WEST SUSSEX COUNTY COUNCIL CONSULTATION

TO:	Arun District Council FAO:Simon Davis
FROM:	WSCC - Highways Authority
DATE:	29 January 2020
LOCATION:	Rear of Inglenook Hotel 253-255 Pagham Road Bognor Regis PO21 3QB
SUBJECT:	P/58/19/PL Erection of 9 No. dwellings with associated access, parking, cycle & refuse storage & landscape design. This application is a Departure from the Development Plan & may affect the setting of a listed buiding. An amendment received.
DATE OF SITE VISIT:	Yes 9th September 2019 and 20th November 2019
RECOMMENDATION:	Advice
S106 CONTRIBUTION TOTAL:

Refuse Vehicle
Swept Path Analysis

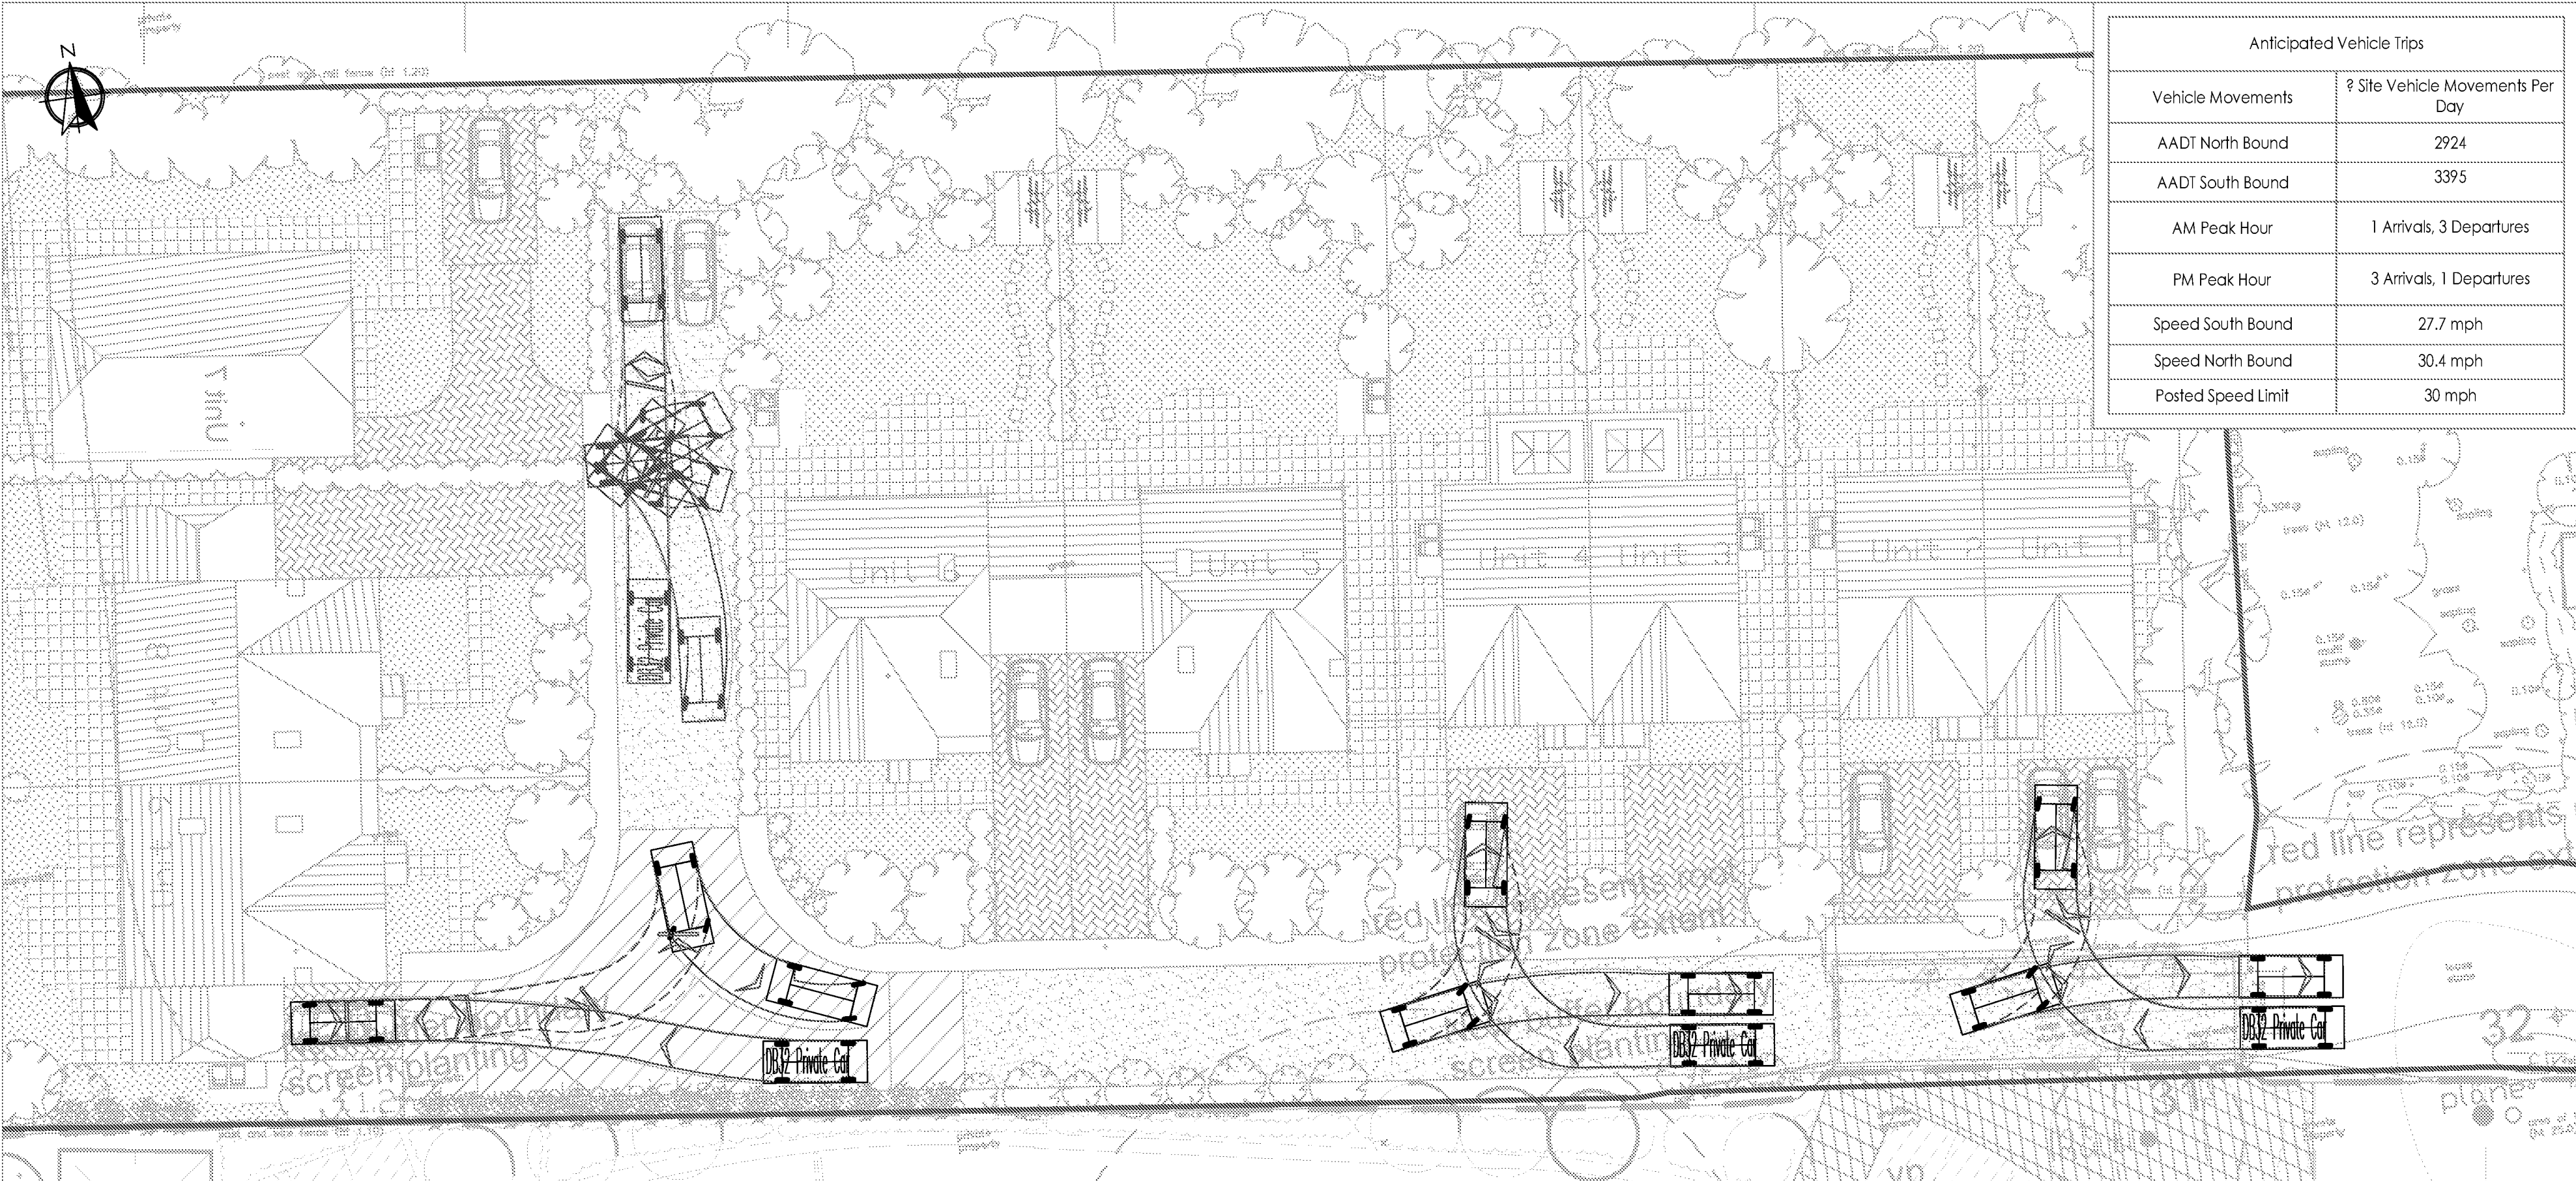
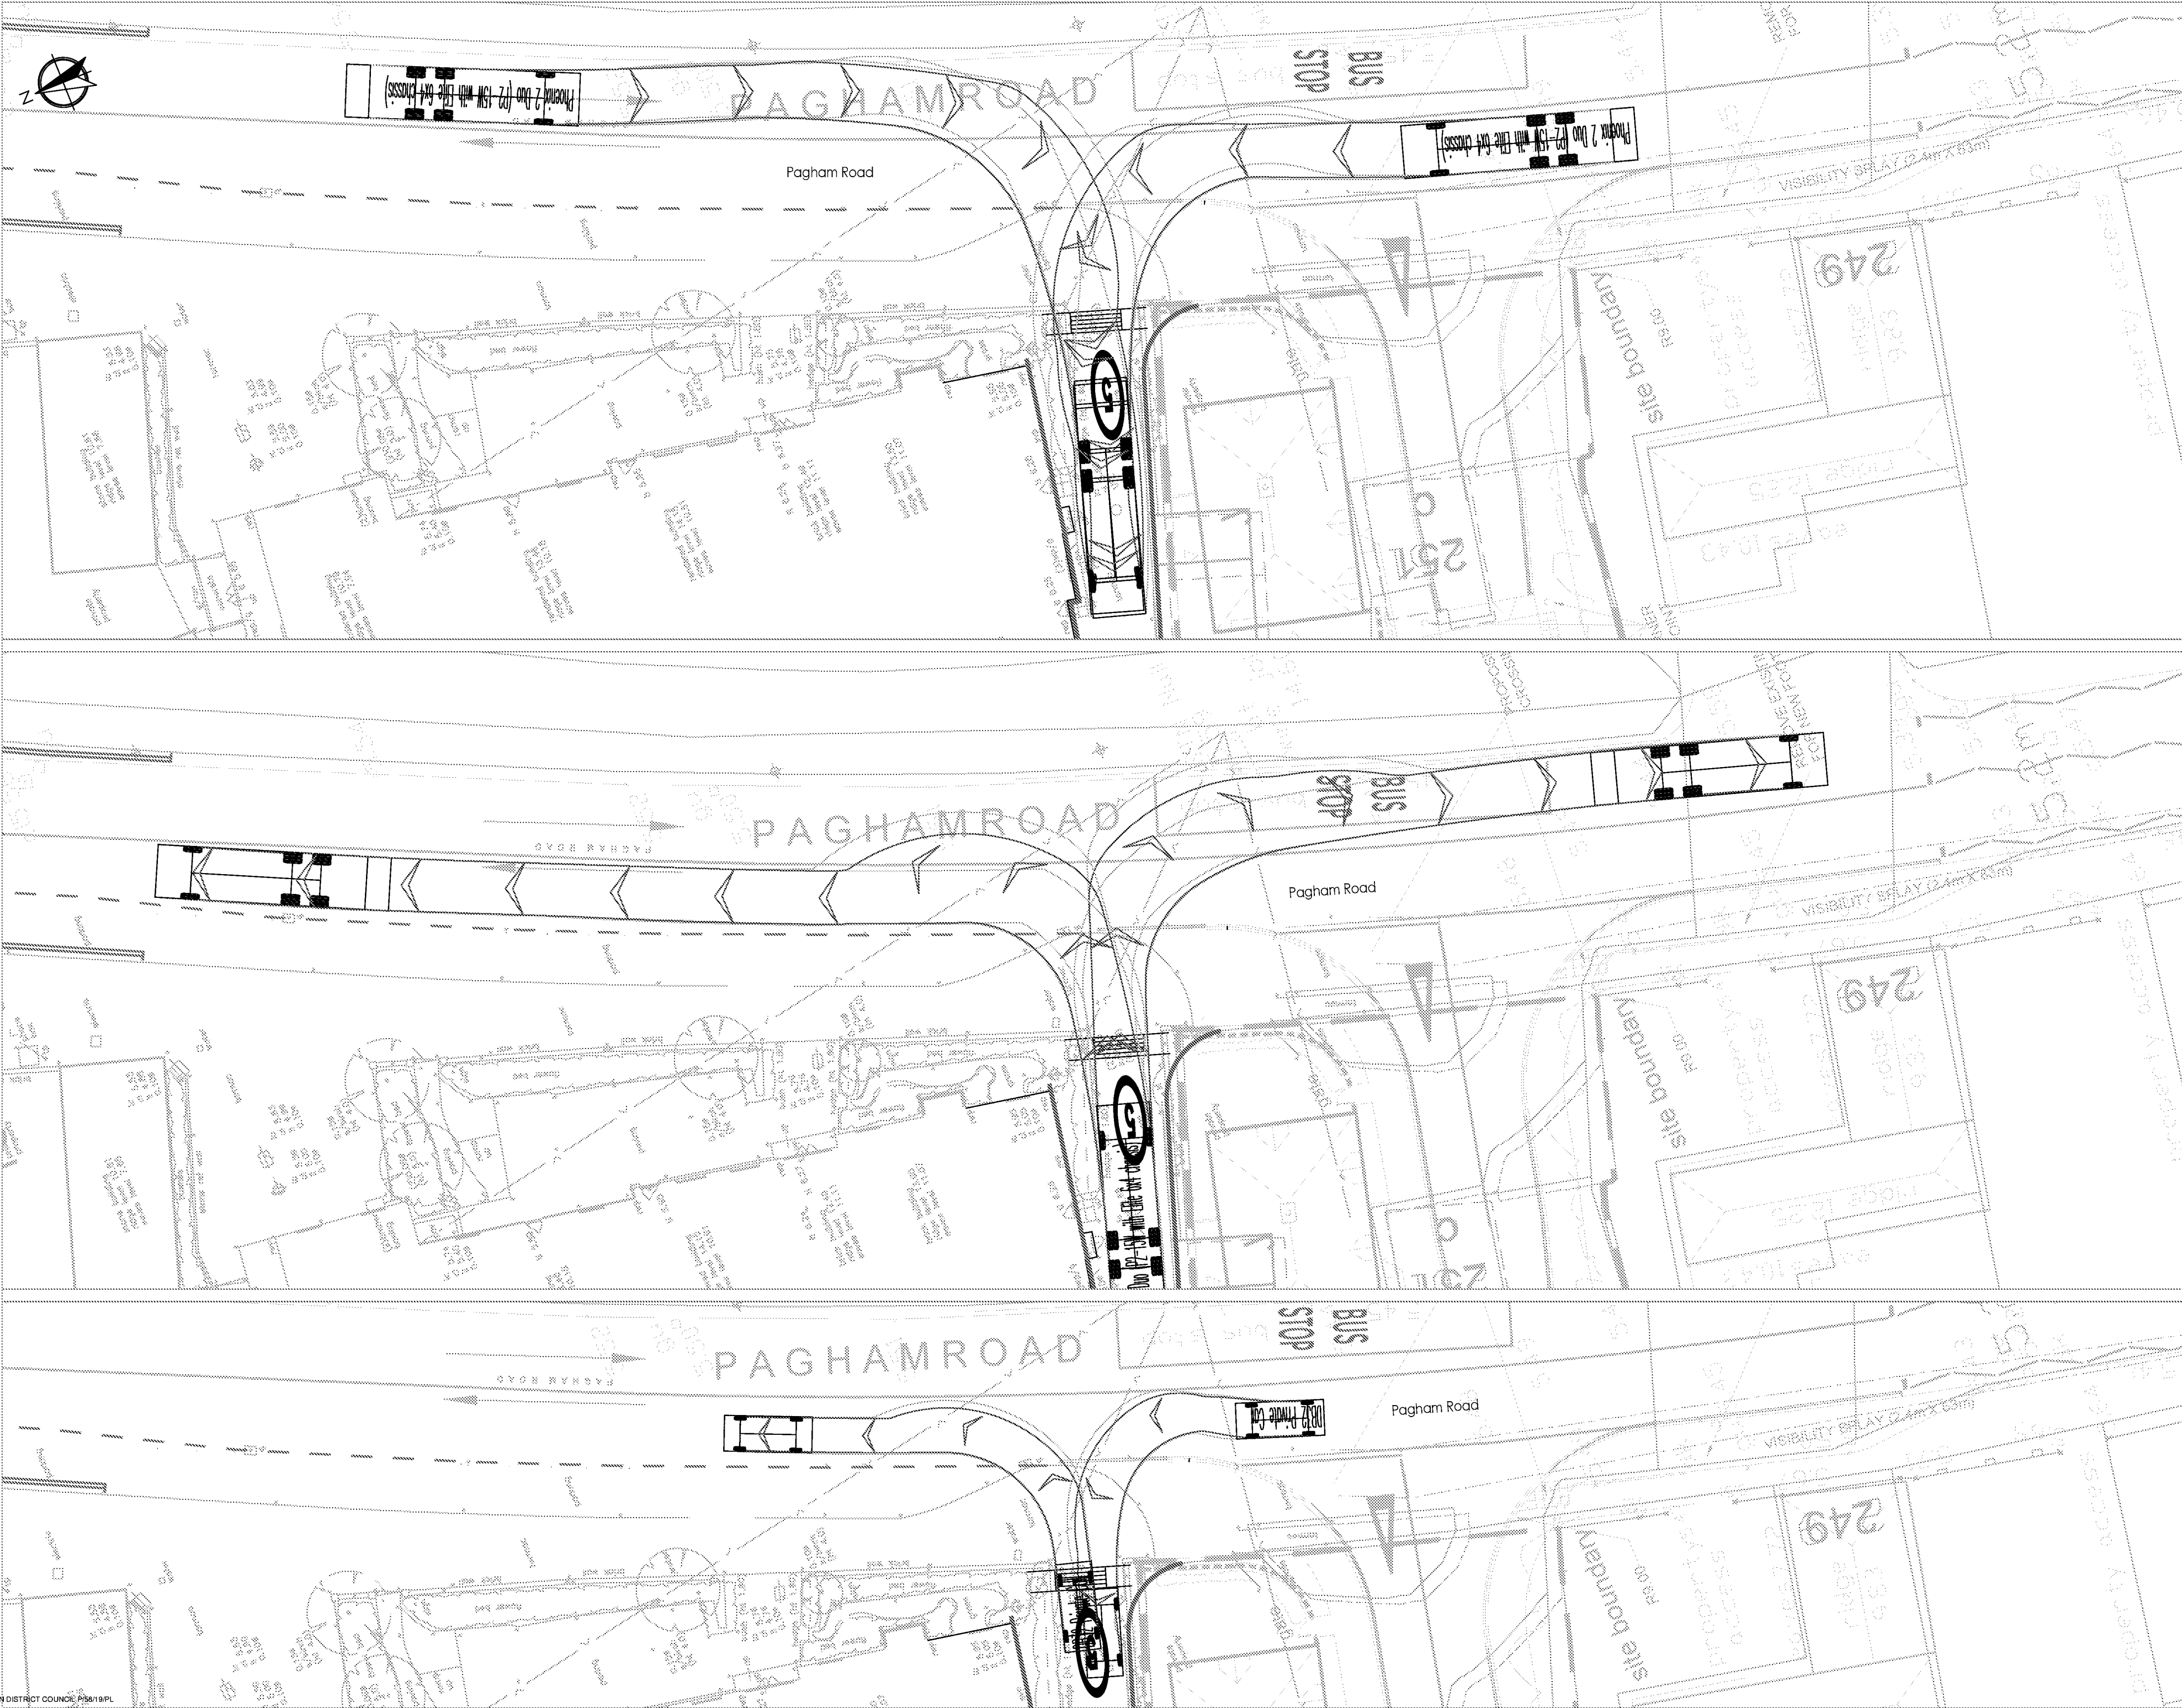
- Concern is raised that the swept path analysis do not take account of any parked vehicles on Pagham Road. Concerns are raised that there are no restrictions and a refuse vehicle would not be able to make a turn with the present arrangements without parking restrictions reducing the existing availability for residents and visitors on-street. We note that the applicant provided swept path analysis drawing 2017/3763/003 Rev B which demonstrates that refuse vehicles would be able to access and egress the site. The LHA observed on site there was a proportion of on-street parking on the opposite side of the carriageway (eastern side) at the time of our visit. In practice if there was the presence of parked cars it would mean that vehicles would make the right turn movement into the site from a more central position on the carriageway. The practice of vehicles entering the site from this position on the carriageway currently occurs as the access is existing. For completeness the applicant may wish to expand this drawing further by providing an additional drawing showing parked cars to the east. This would only be required for a vehicle accessing from the north. The right turn movement out of the site and left turns in from both the north and the south would be unhindered by parked cars due to the nature and location of parking and the presence of double yellow line parking restrictions and a bus stop. We are aware that the Waste Collection Authority have made comments on the arrangement and have no adverse comments to make in relation to the proposed layout.

The LHA having now assessed the latest information would still advise that our advice from previous consultations would still stand. The advice above relating the the swept path diagrams should be taken into account by the applicant. The previously advised conditions and informative would still stand. WSCC as LHA does not considered that there is any transport or highway reason that this application should be refused and that from a transport context the development is policy compliant.
